TRI-STATE GENERATION & TRANSMISSION, INC.

FOX RUN SUBSTATION FINAL DRAINAGE REPORT

PCD FILE # PPR-22-044

October 11, 2022

**DRAINAGE BASIN DELINEATION**

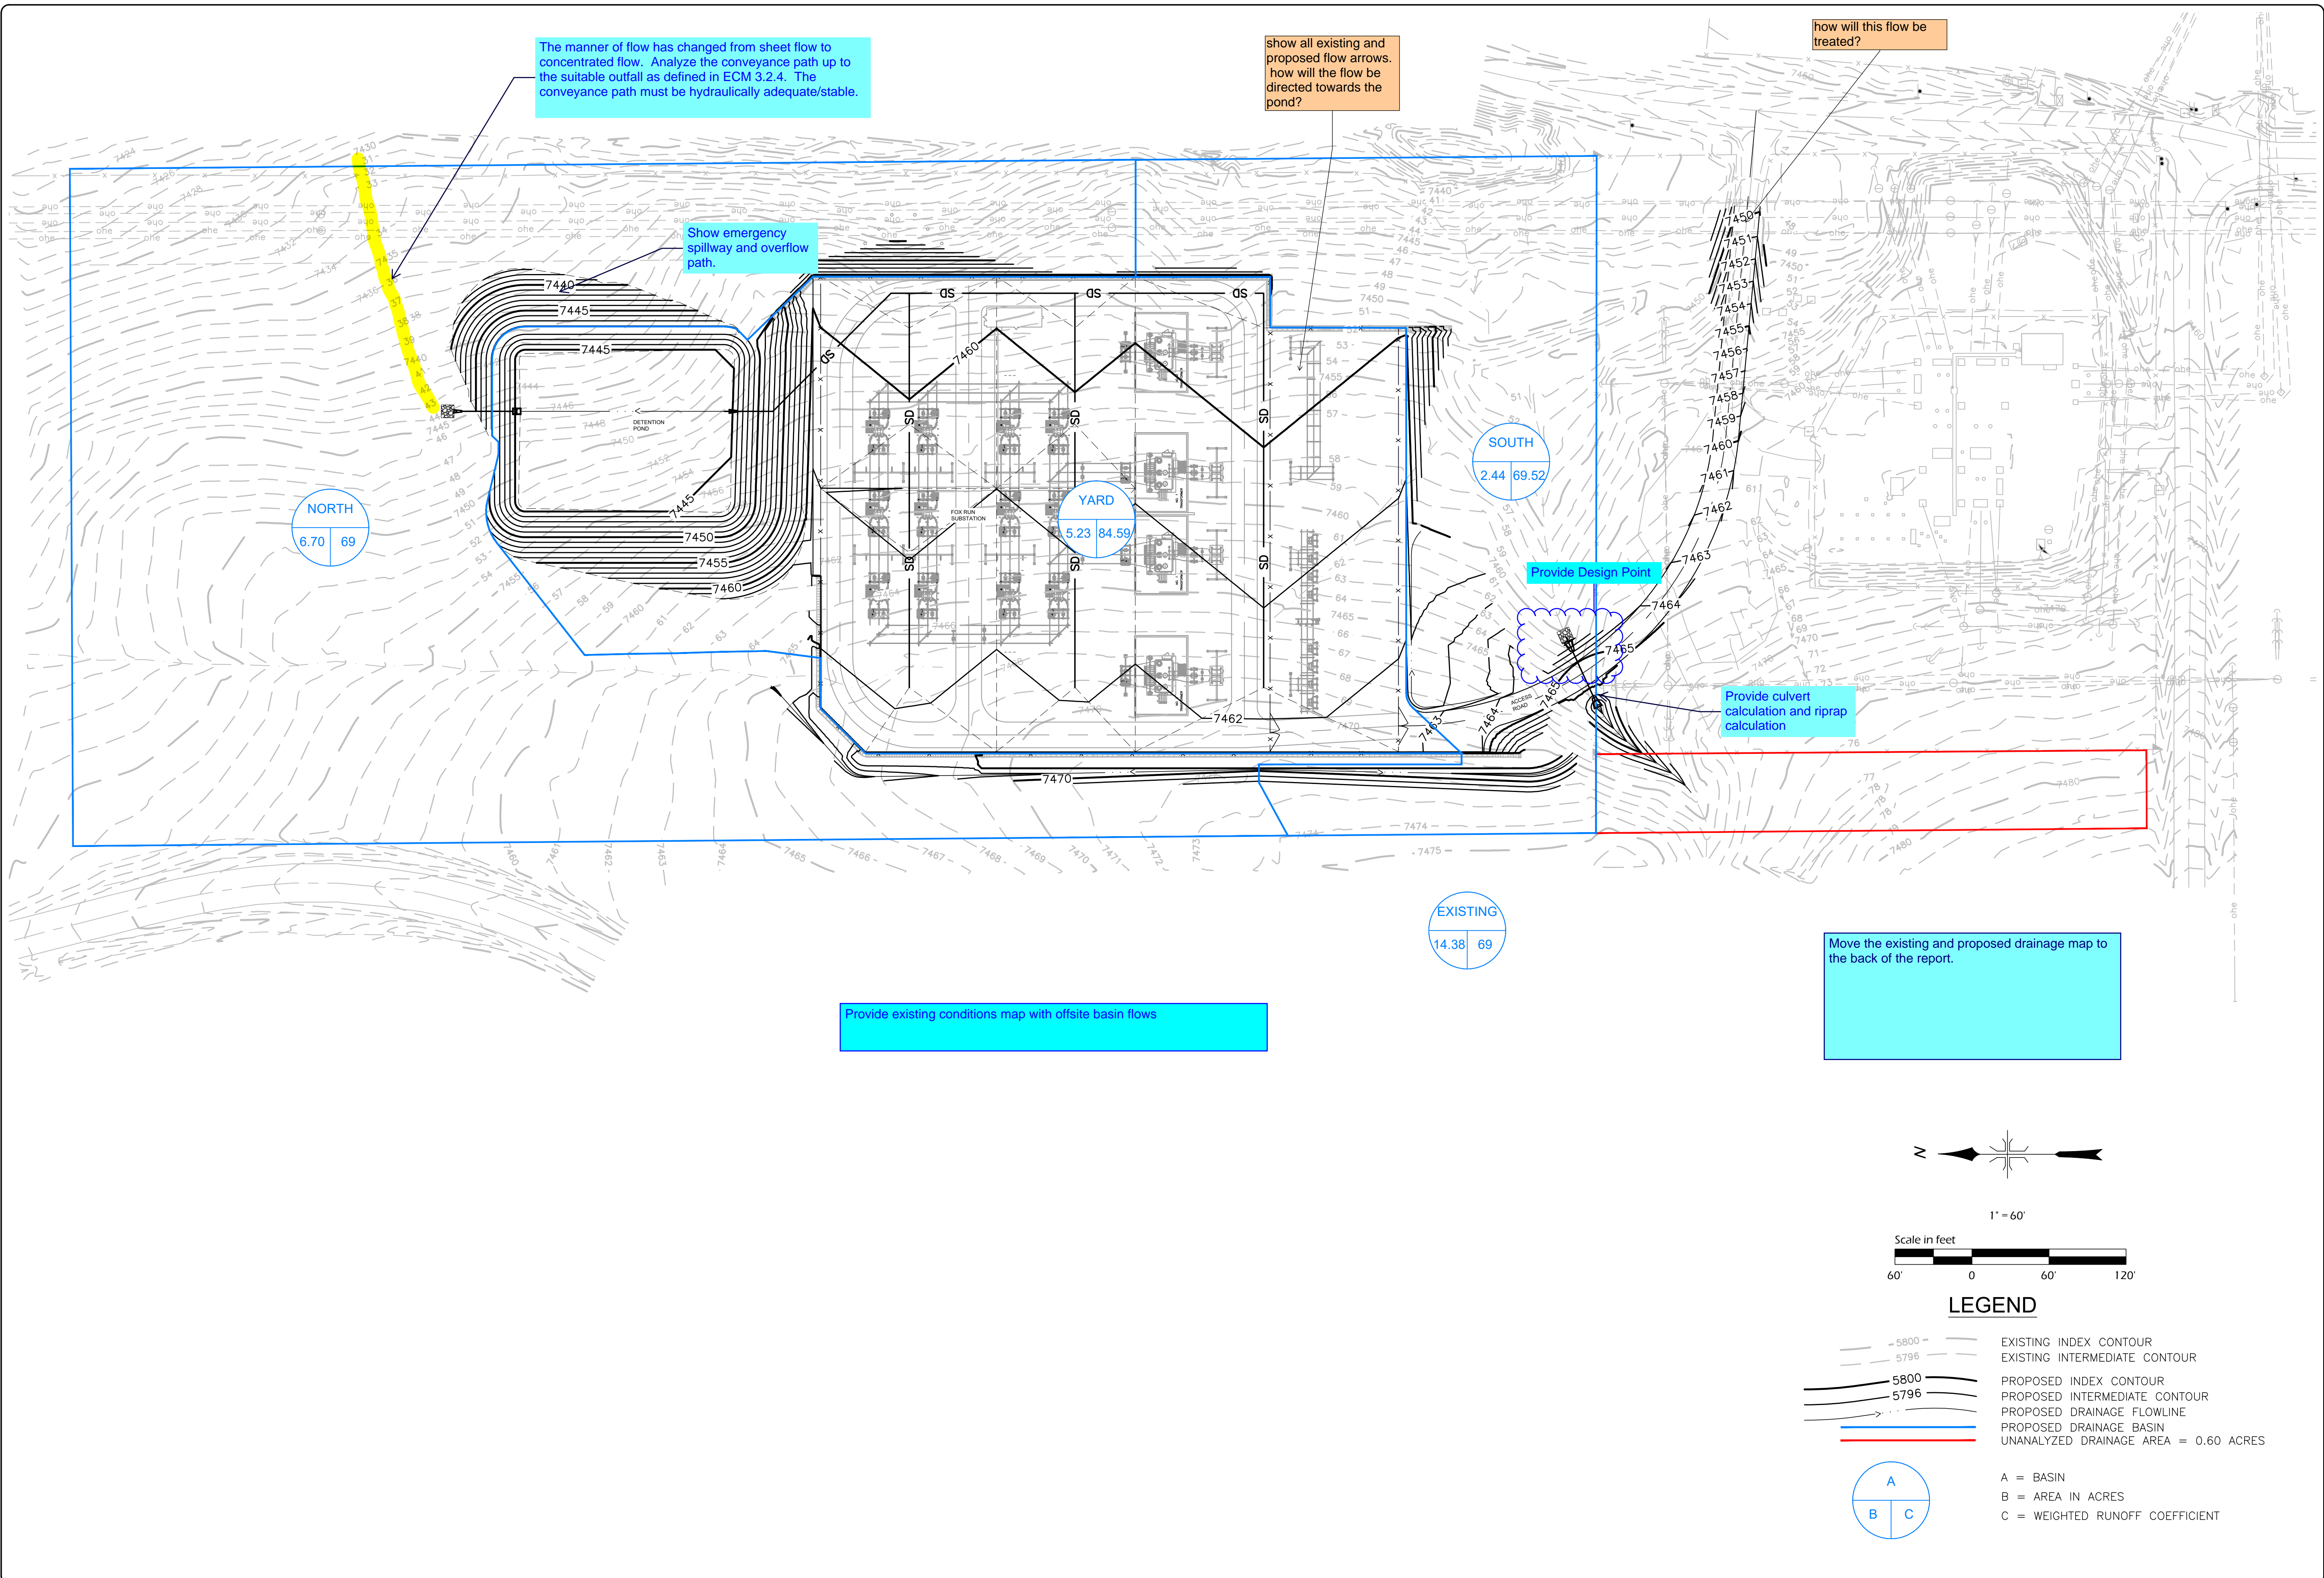
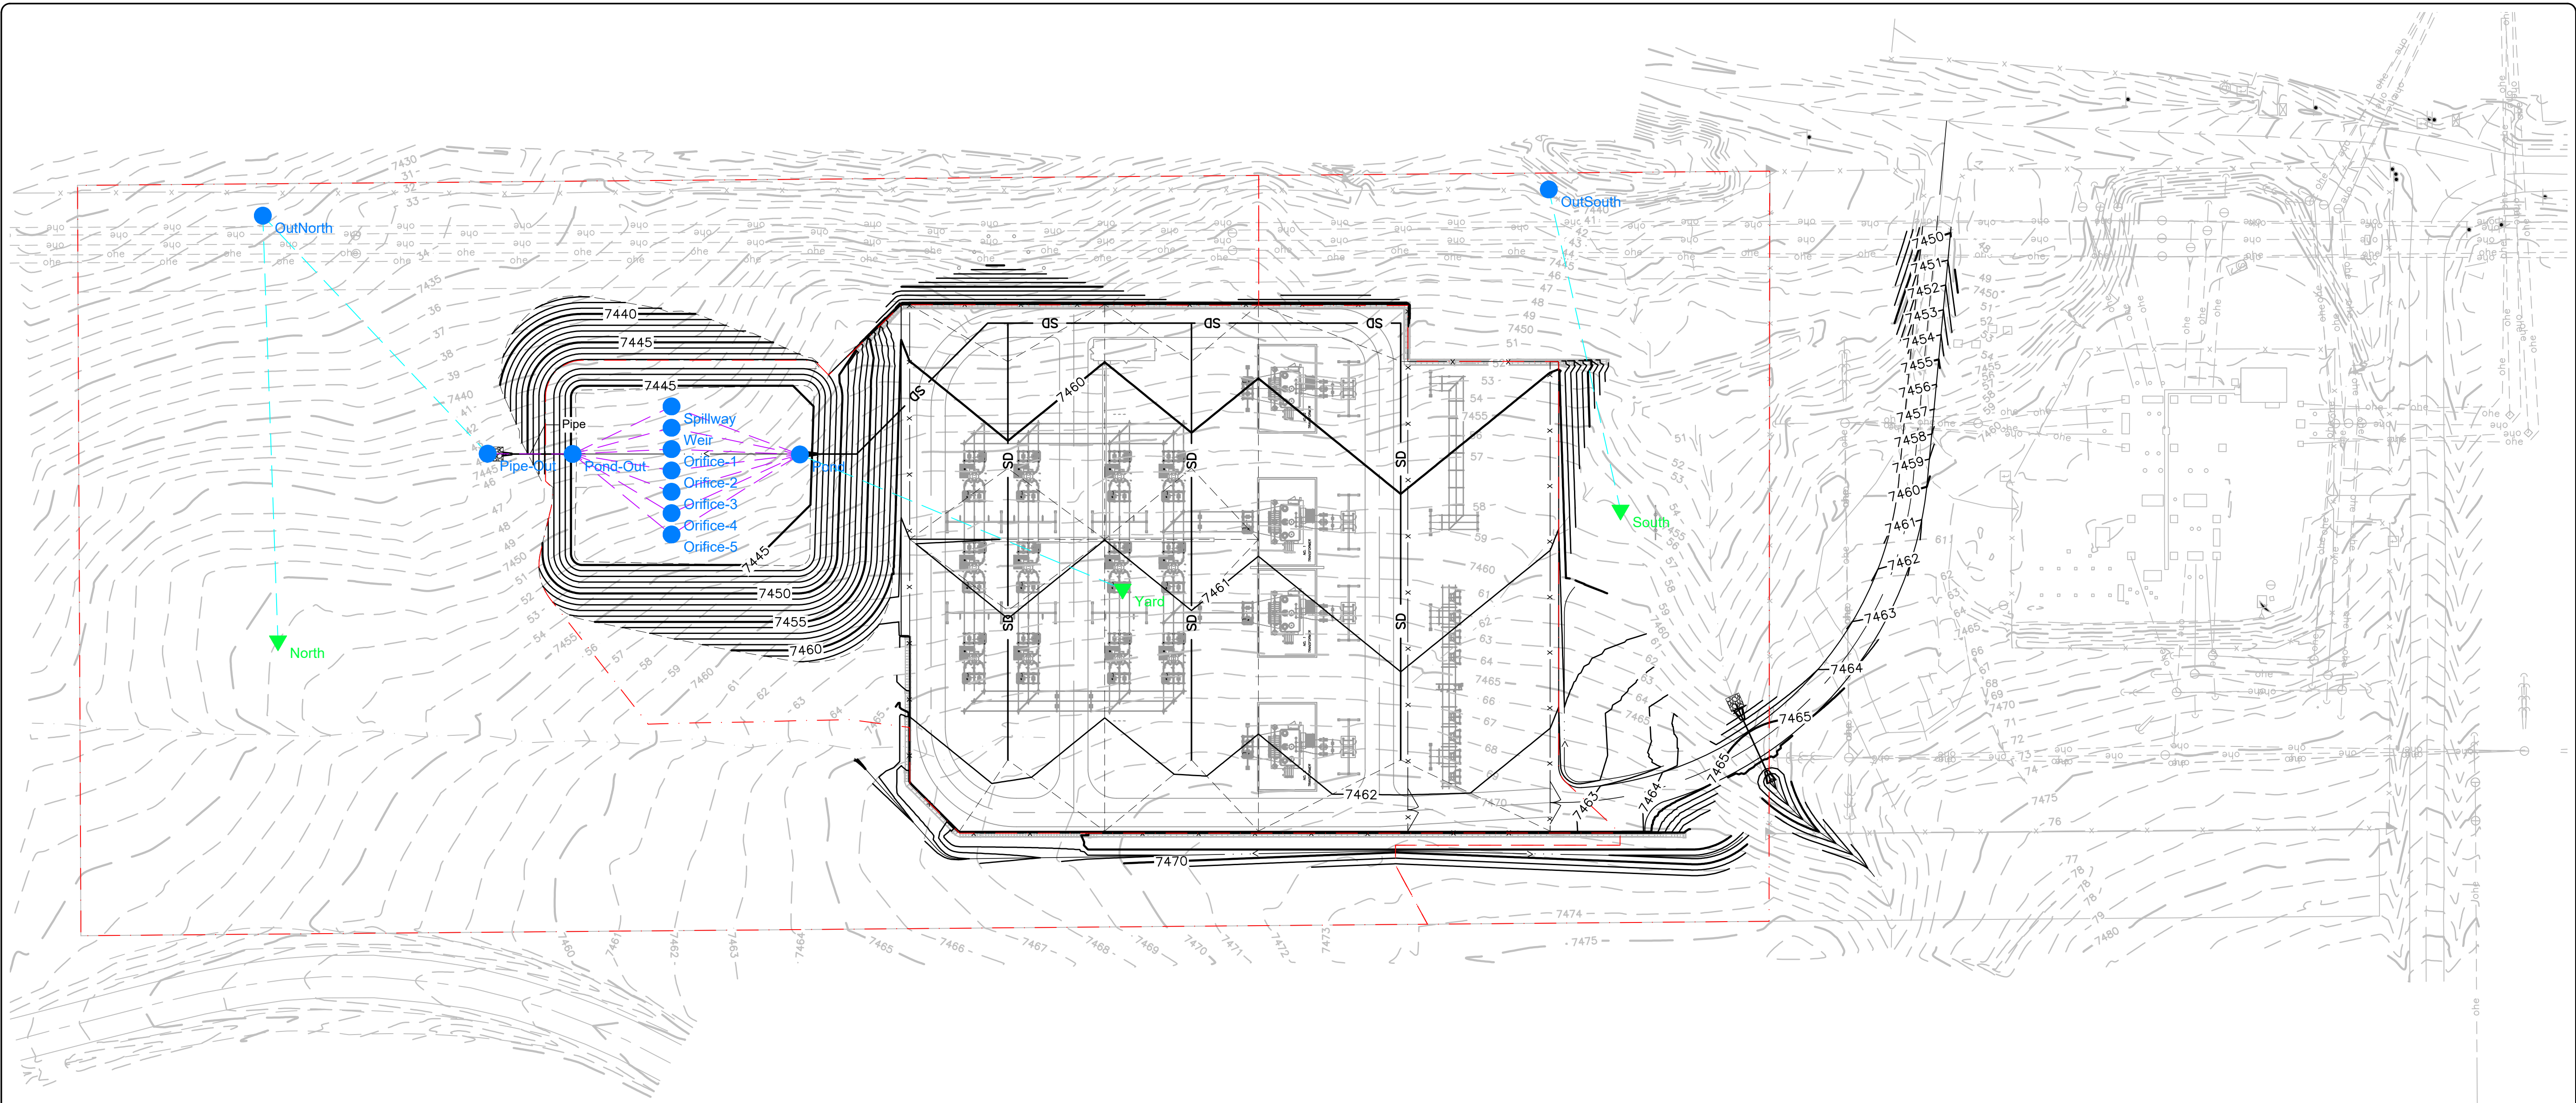
show existing flow arrows unresolved.

There are basins that are not being captured by the proposed ponds. Explain in the narrative how WQ is being addressed for these basins. Possible exclusions include I.7.1.B.7 (land disturbance to undeveloped land that will remain undeveloped) and/or I.7.1.C.1 (which allows for 20% not to exceed 1 acre of the applicable development site area to not be captured).

include basin for this disturbance and WQ

Provide existing conditions map with offsite basin flows
Unresolved - ddschoenheit
12/08/2022 7:28:55 AM

Existing conditions and basin map should show parcel without new structures and development. Show flow arrows pre-development
